WELWYN HATFIELD COUNCIL – DEVELOPMENT CONTROL
DELEGATED REPORT

APPLICATION No:	S6/2010/2314/FP
------------------------	------------------------

The proposal is to create a loft conversion incorporating one rooflight on the front elevation and three rooflights on the rear elevation. The conversion will create two habitable rooms. The applicant has advised that one of these rooms will become a bedroom

FRONT

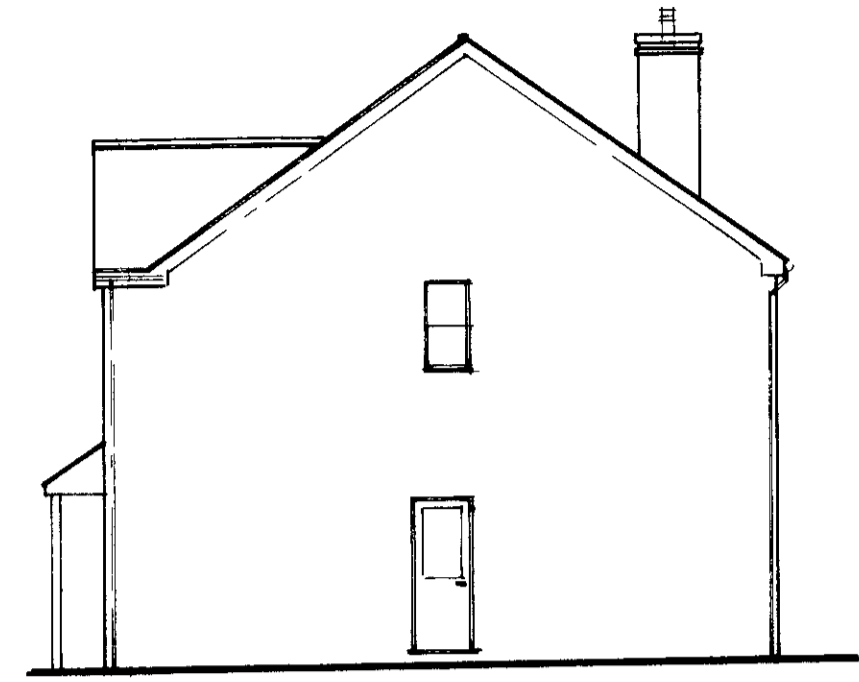
Hatfield Town Council express concern on the proposed rooflight to the front of the house. An objection would be made if this was the first house in the street to propose a rooflight in the front of the house.

Rooflights on the front elevation within this area of Hatfield Aerodrome are not a common feature however, the proposed front elevation rooflight on No.58 is minimal in size and is not considered to appear overly prominent within the streetscene. The proposed rear elevation rooflights are not publicly viewable due to the open countryside to the rear. The proposed rooflights therefore comply with policy D1 and D2 of the Welwyn Hatfield District Plan, 2005

REAR

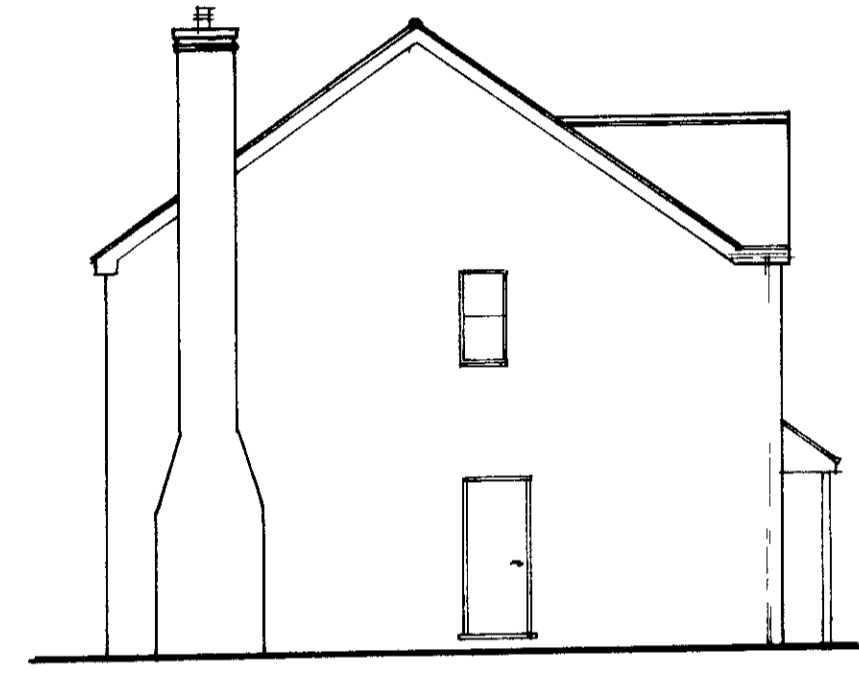
The proposed rooflights are not considered prominent from adjoining properties or result in any additional overlooking. No windows are proposed on the side elevations of the existing loft space. The proposal does not pose any impact on the amenity of adjoining properties and therefore complies with policy D1 of the Welwyn Hatfield District Plan, 2005.
